MACQUARIE UNIVERSITY

AUSTRALIAN HEARING HUB

ACCESS REVIEW – PROJECT APPLICATION

4th May 2010

BASEMENT 1

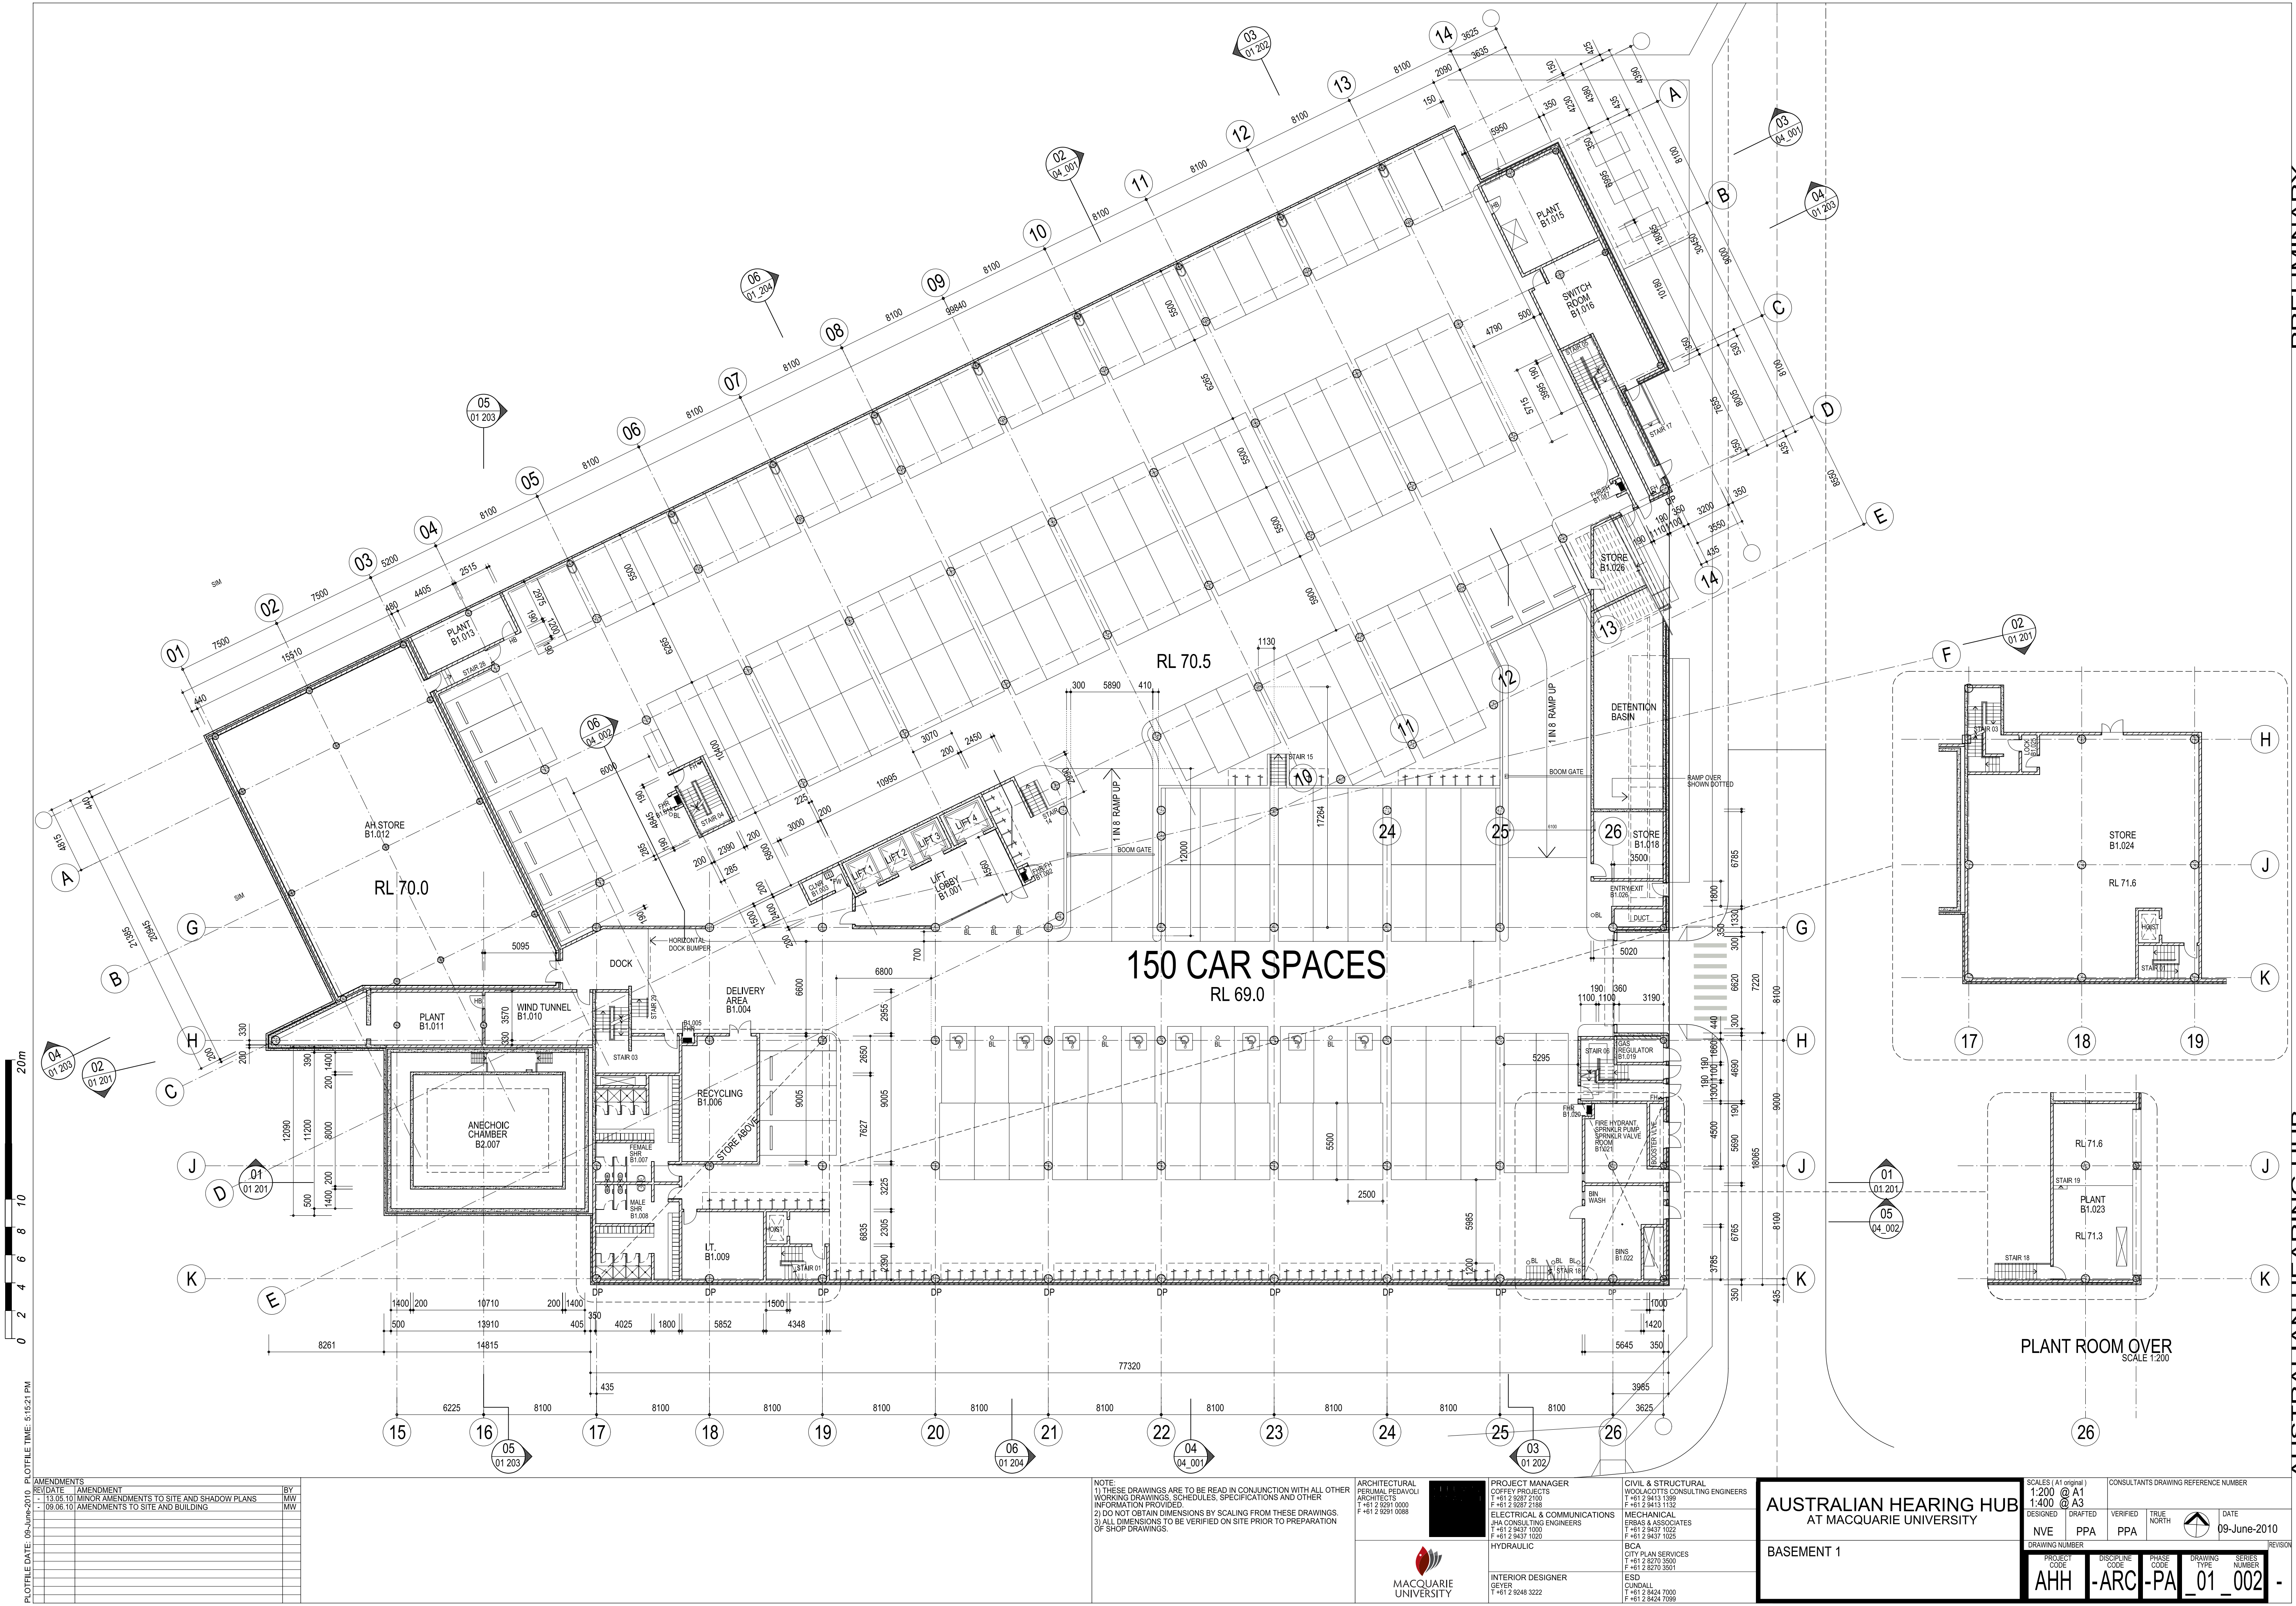
There are 172 carspaces on level 1 & 165 car spaces on level 2. There are 6 accessible carparking bays located on level 2 near the passenger lifts.

The accessible car bays have a 2400mm (W) x 5500mm (min) internal dimension with adjacent shared bays in accordance with AS2890.6. This is suitable in lieu of the 3.66m width accessible car bays required under Council DCP.

- (i) Provide 3% (11) of total car bays to be designated as accessible car bays, compliant with Ryde DCP 2006 9.2 Clause 16.1& Table 1.
